From: Richard Temple
Sent: 14 November 2017 16:20
To: Karen Garner
Subject: FW: Wellow Barn, Hoe Lane, Flansham Bognor Regis. Y/57/17/L
Attachments: Prop Site Plan 100 1.pdf

Application Number	Y/57/17/L AND Y/56/17/HH
Address	Wellow Barn Old Barn House Hoe Lane Flansham PO22 8NT
Description	Application for Listed Building Consent for a Detached carport
Case Officer	<u>Mr R Temple</u>
Date	14 th November 2017

The application is for a substantial carport with integral log store.

PROPOSED PLOT PLAN

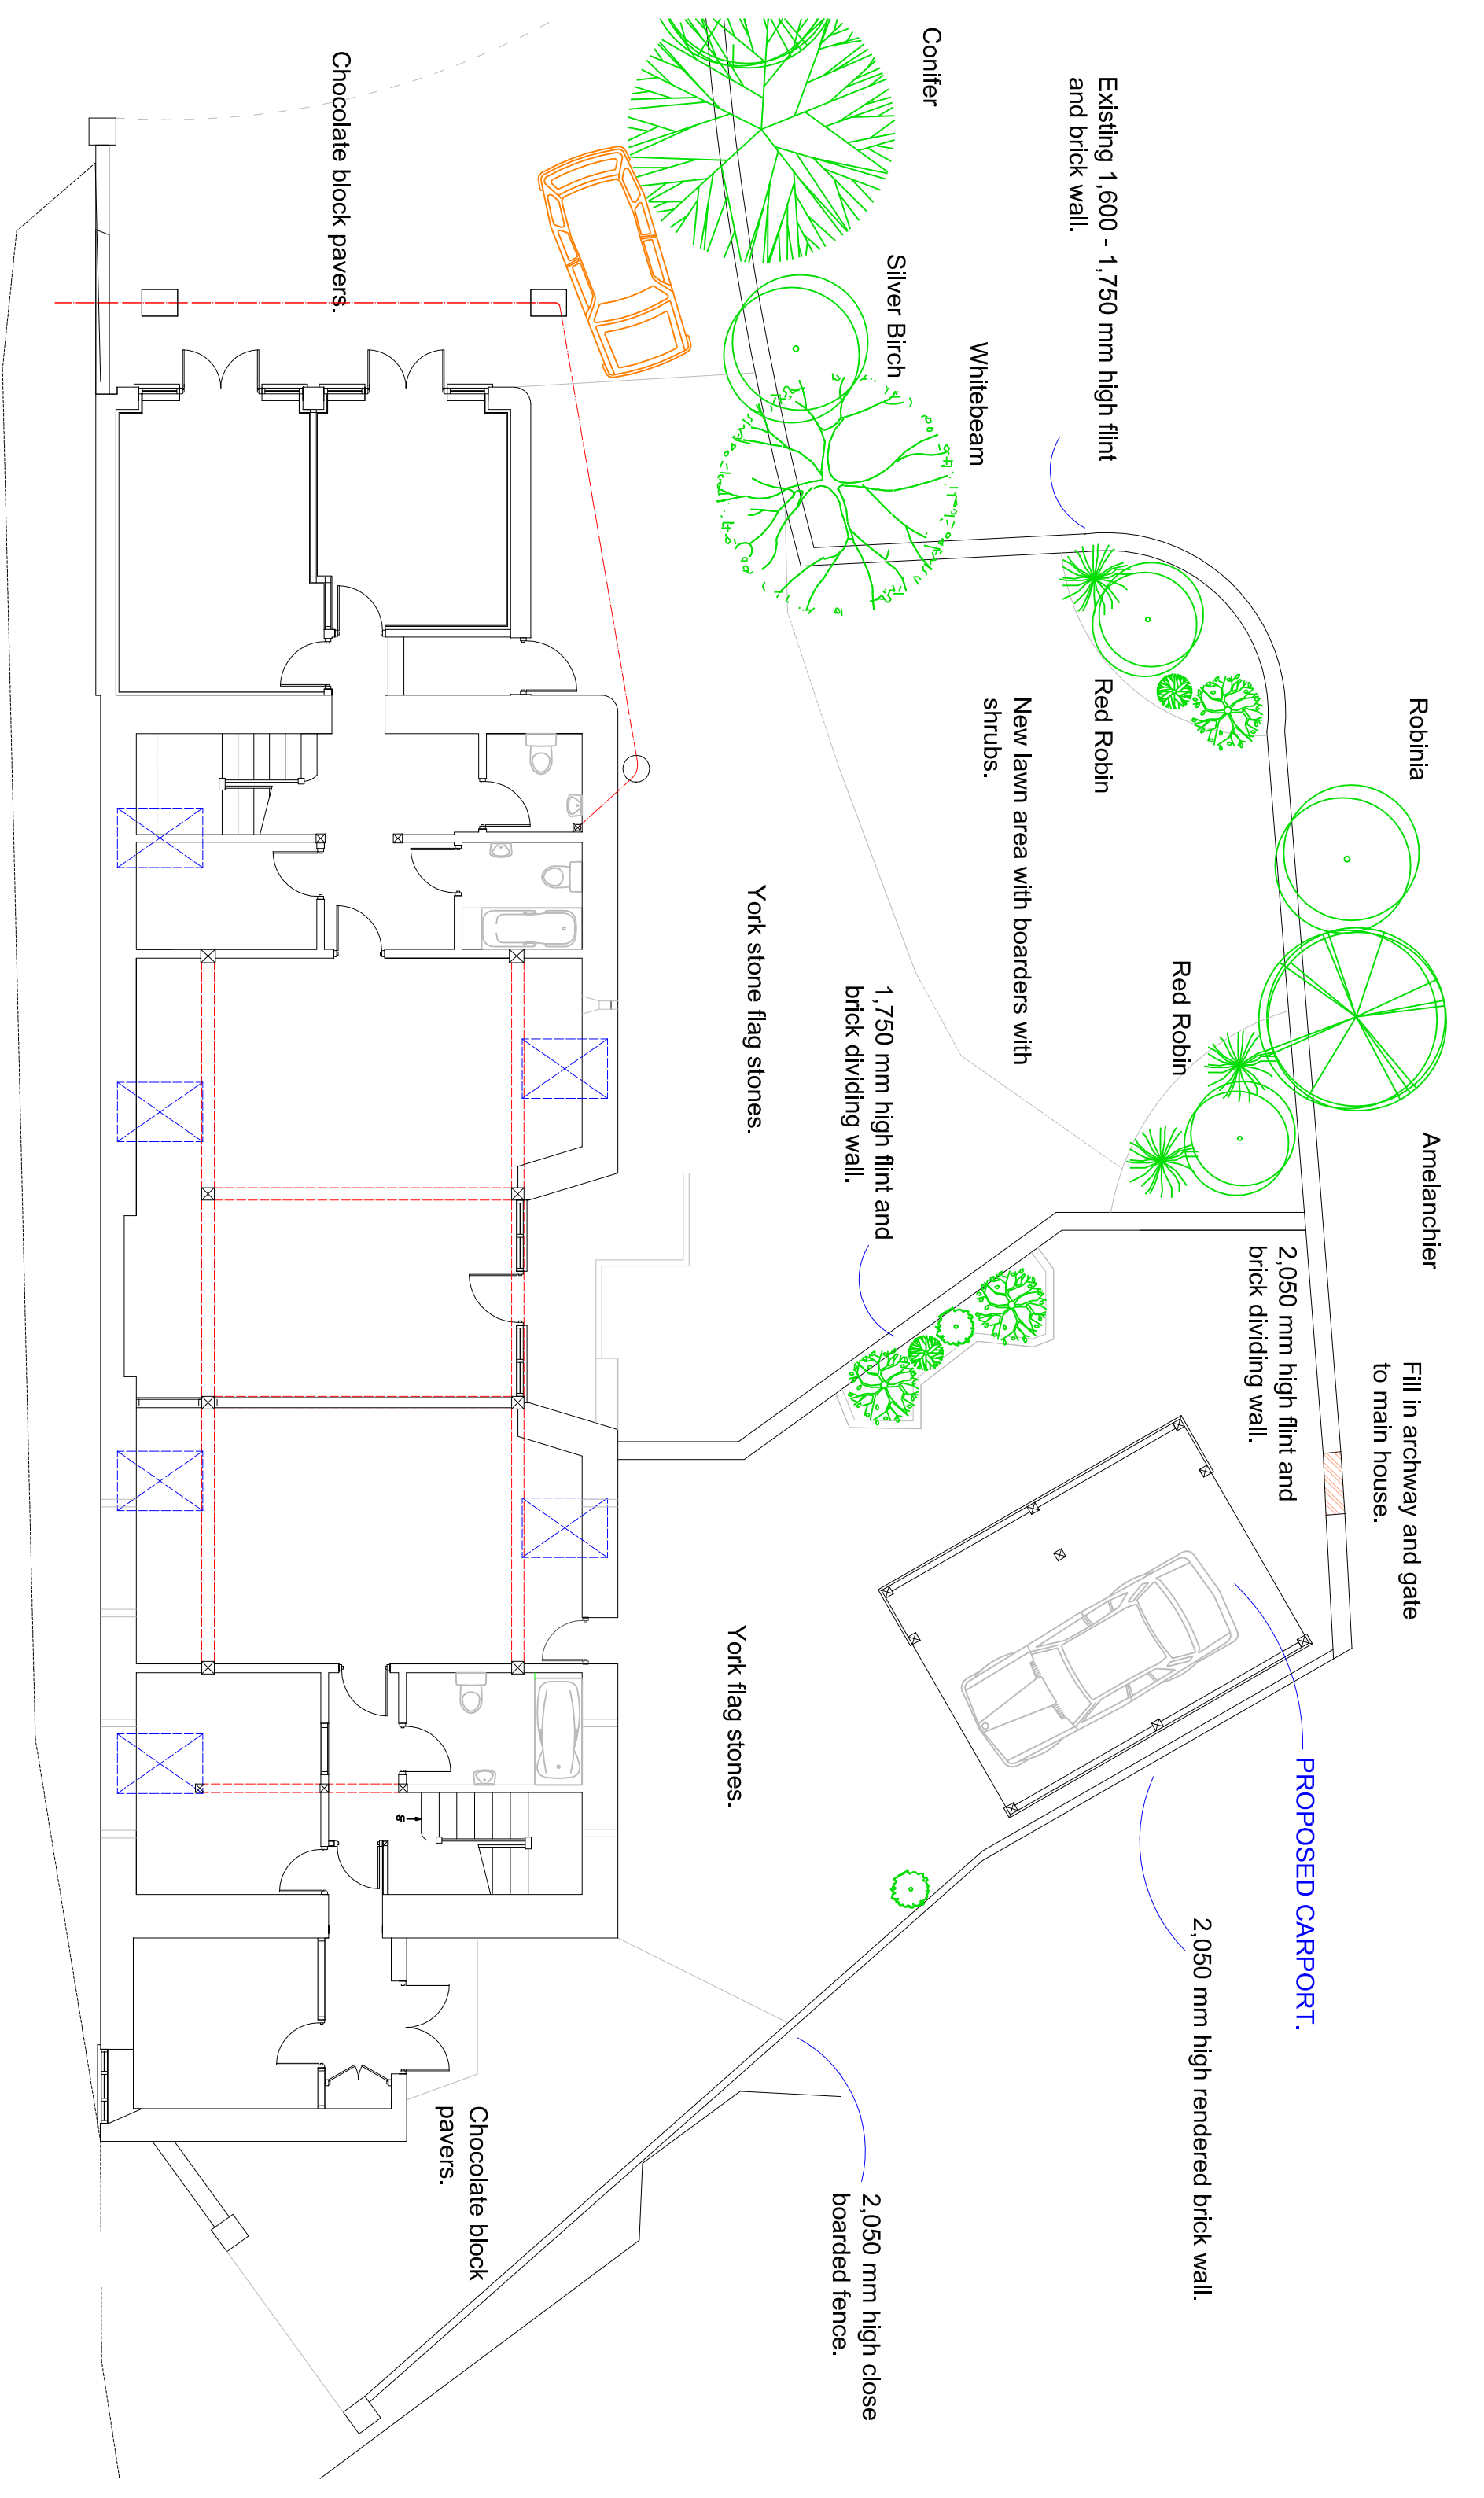
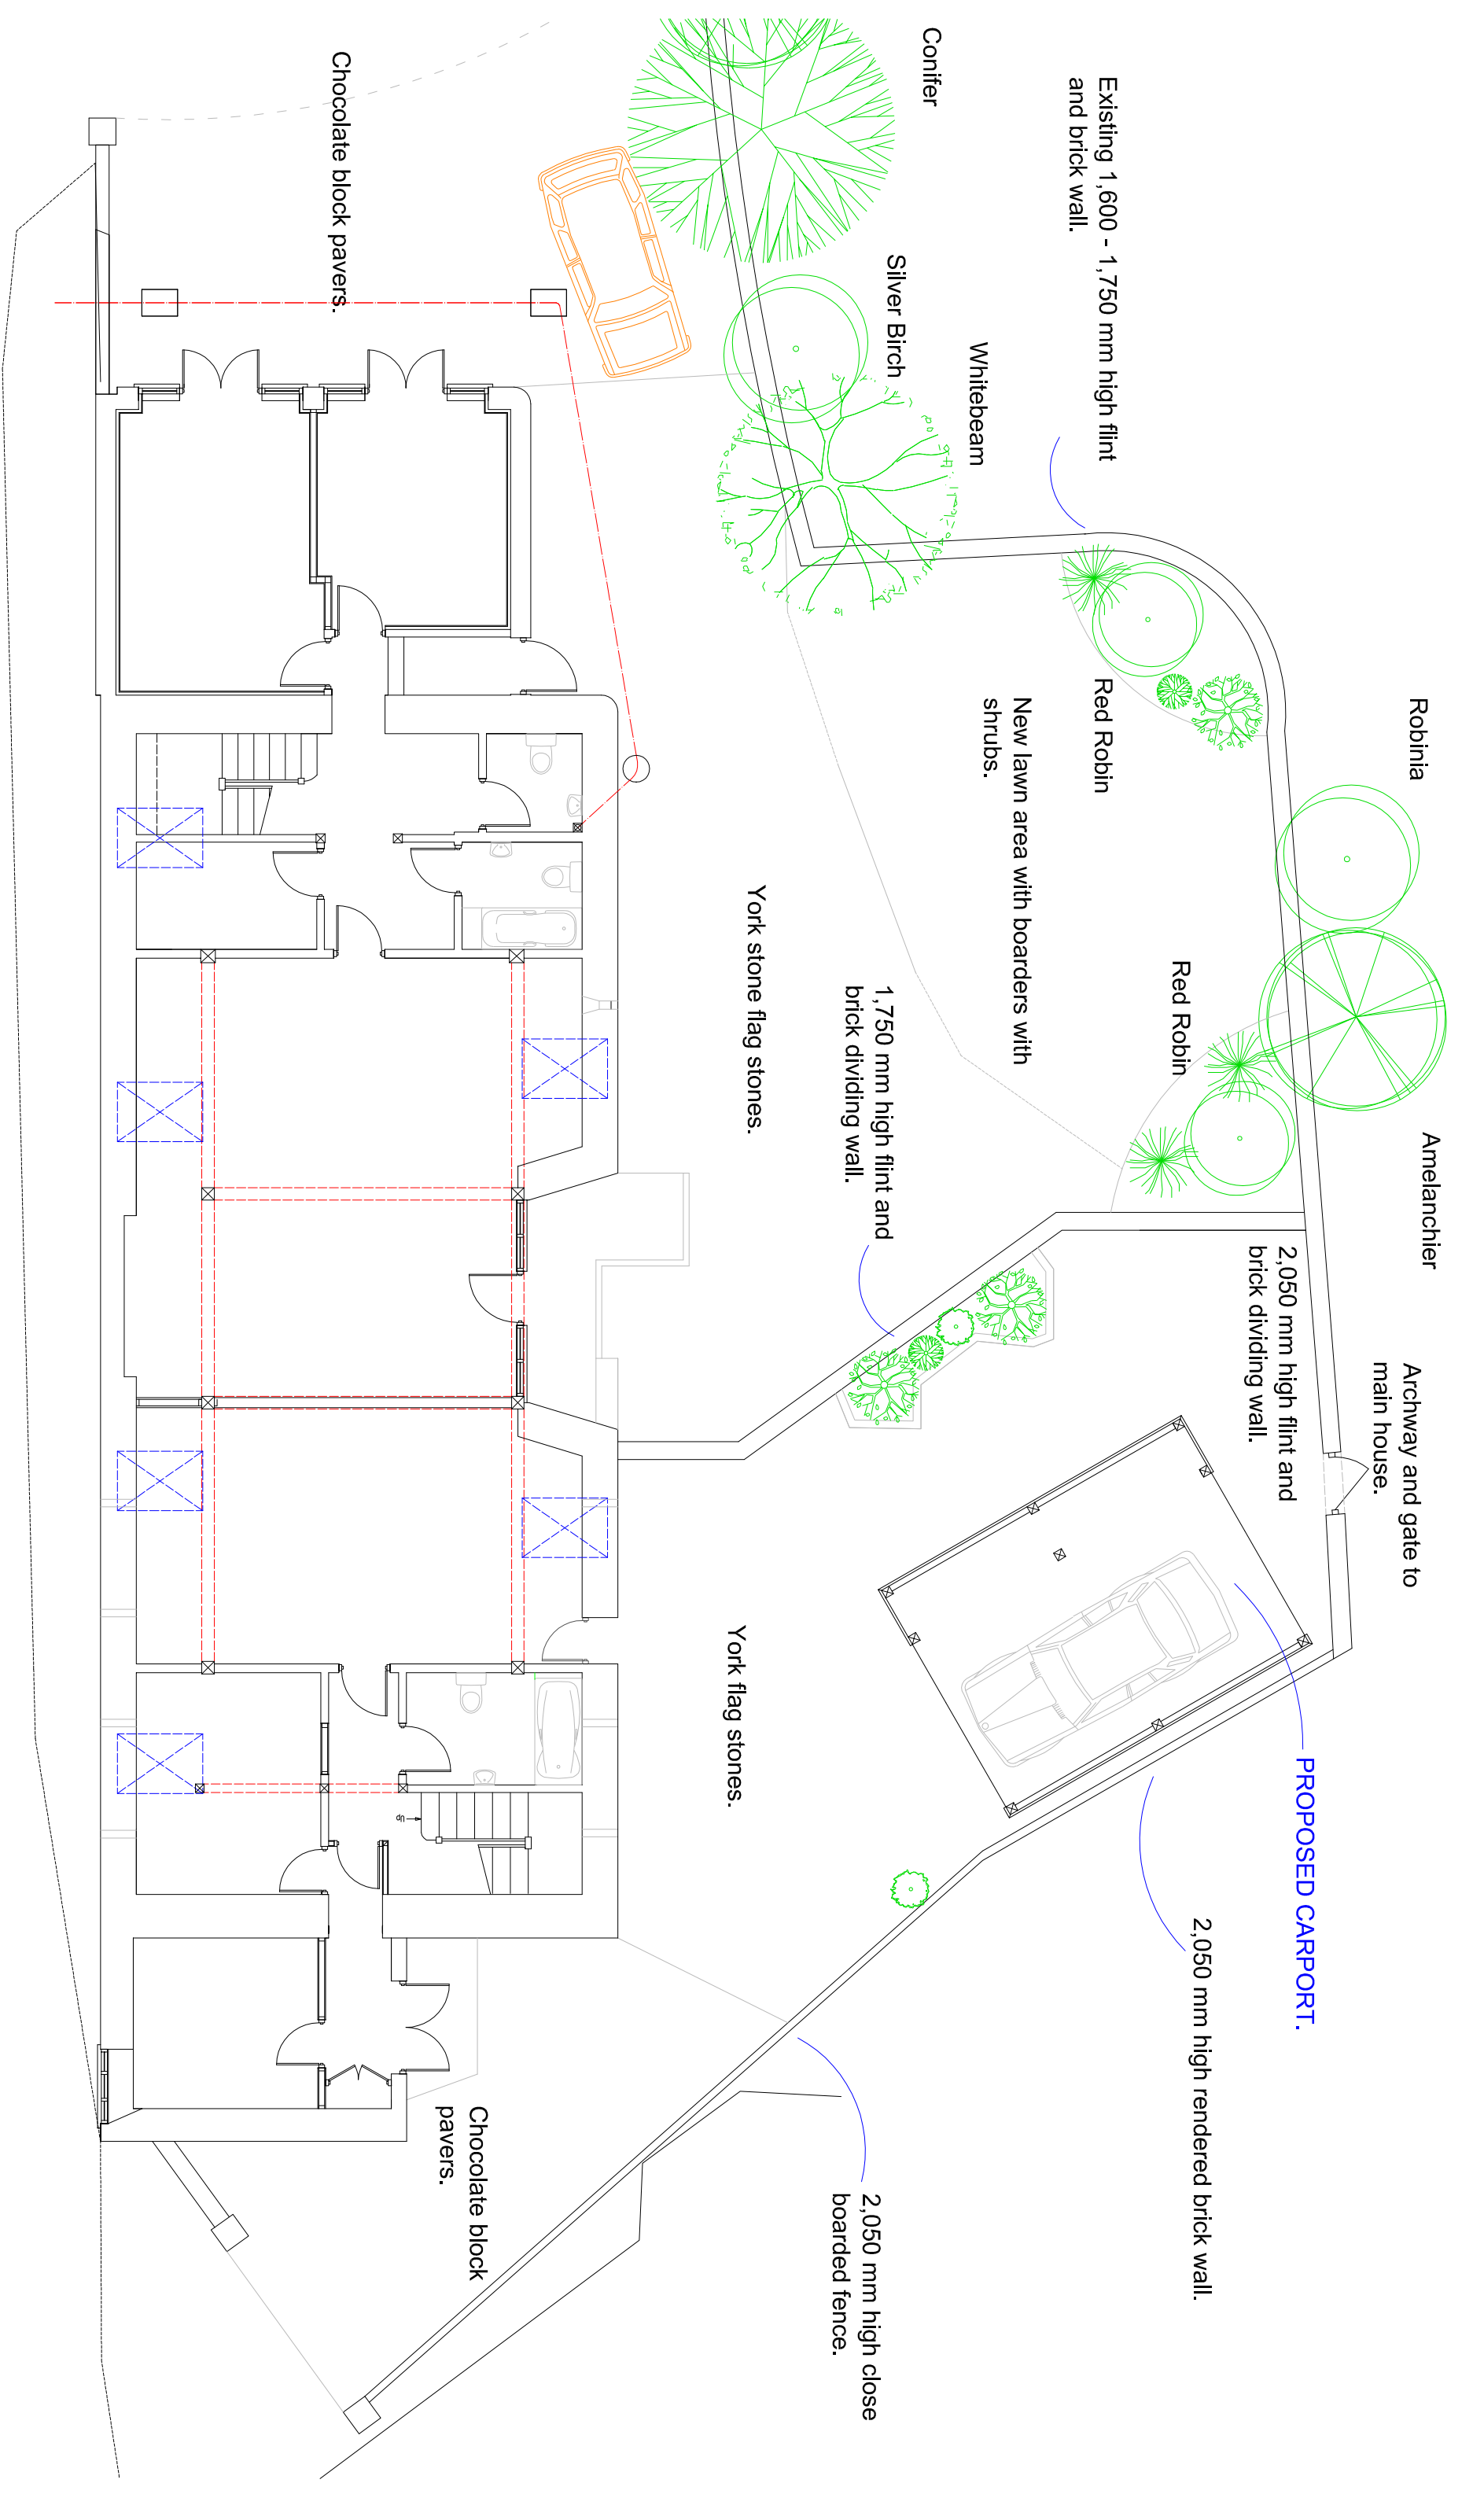
The proposal also details the blocking up of an existing, historic gate. This element represents a historic link between the house and ancillary buildings, and it is recommended that this feature be retained, and not blocked up as detailed on the submitted plans.

Please let me know if you are willing to omit the blocking up of the door from the proposals. We would also look to include a pre-commencement condition for the exact details of proposed materials.

Regarding the Conservation Officers comments – I attach revised plans retaining the gateway as requested. I hope that this allows you to process the applications/s towards a positive decision and I look forward to hearing from you.
